HINCKLEY NATIONAL RAIL FREIGHT INTERCHANGE

Applicant's response to Deadline 6 Submissions [part 5- Non-Statutory Bodies]

Document reference: 18.20

Comments	Applicant's Comment
HINCKLEY RAIL FREIGHT TERMINAL Comments for Deadline 6 CPRE Leicestershire Unique Reference: 20038675 (With Sapcote Parish Council (UR 20039514)) February 2024

Figure 5-4: Cycle Route Enhancements

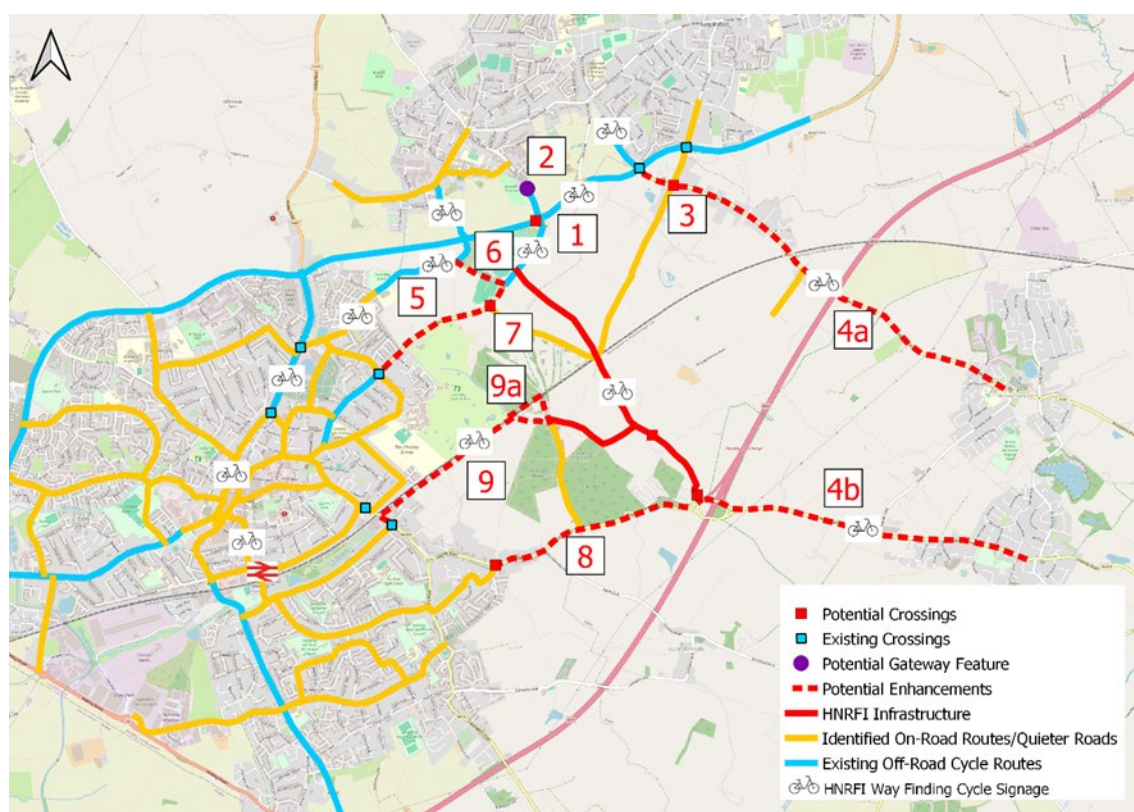
<p>3.1 The updated Sustainable Transport Strategy includes a new opening section entitle commitments:</p>	
<p>3.2 Para 1.9 states that: Many options are already available to cyclists travelling to Hinckley, Barwell and Earl Shilton, however the enhancements identified provide alternatives and additional options for cyclists. The STS satisfies National policy for sustainable travel without these additional enhancements however the applicant in seeking to work collaboratively with the LHA have explored further cycle enhancements and identified three schemes which can be progressed through this Sustainable Transport Strategy.</p>	<p>Noted- the enhancements are to provide commitment to improving mode share for cyclists as the development is built out.</p>
<p>3.3 This is echoed in the new Para 8.1 of the Travel Plan: 8.1. As can be seen from Figure 5-4 many options are already available to cyclists travelling to/from Hinckley, Barwell and Earl Shilton. Three viable enhancements have been identified over and above the proposed infrastructure that could be delivered within public highway, but are subject to post DCO consent detailed design, being within highway boundary and technical approval. The enhancements identified provide alternatives and additional options for cyclists. The STS satisfies National policy for sustainable travel without these additional enhancements however the applicant in seeking to work collaboratively with the LHA. 8.2. These additional enhancements are: • Option 1 – Enhancement to Barwell, Toucan crossing on A47 • Option 2 - Enhancement to Barwell, Gateway at The Common • Option 8 – Enhancement to Hinckley and Burbage,</p>	<p>Noted</p>

<p>3.4 A number of options have been identified and the STRAVA data (as previously discussed) supports those but the new options are limited, especially in relation to the Eastern villages. What the text still does not acknowledge is the disincentive to cycle on routes where there are significant traffic increases.</p>	<p>The primary focus of the STS has been to identify appropriate non-car modes for a number of users and destinations. The DRT provision and Car Share is a major focus for settlements that sit at or beyond the 5km catchment but have lower populations when compared with Hinckley and Barwell. The cycle infrastructure enhancements are focused on where they are likely to achieve the biggest mode share and are typically segregated from the main carriageways providing safer cycling routes.</p>
<p>3.5 Both paragraphs refer to these 'additional enhancements' but not increased actual cycling.</p>

<p>3.6 We consider the result of these proposals will be a significant disincentive to cycle on more-congested routes.</p>	
<p>4.0 Modelling TR050007-002127-18.18 Hinckley NRFI M1 J21 Modelling Note</p>	
<p>4.1 This note takes flows derived from a traffic model that is designed to take account of the limited capacity of links and junctions. The modelled flows therefore reflect this by showing very minor changes where congestion is severe. It notes that background traffic will have been displaced to other routes.</p>	<p>The M1 J21 Modelling note provides a summary of the key congestive impacts. This has assessed the observed and forecast flows with commentary on each to be read in conjunction with the information provided within the Transport 2023 Update (document reference: 18.13.2, REP4-131). Its conclusions remain unchanged from the original submission documentation.</p>
<p>4.2 It refers to recent traffic counts of observed traffic. Observed traffic counts will also reflect the congested nature of the junction and obviously do not take account of any currently displaced traffic or</p>
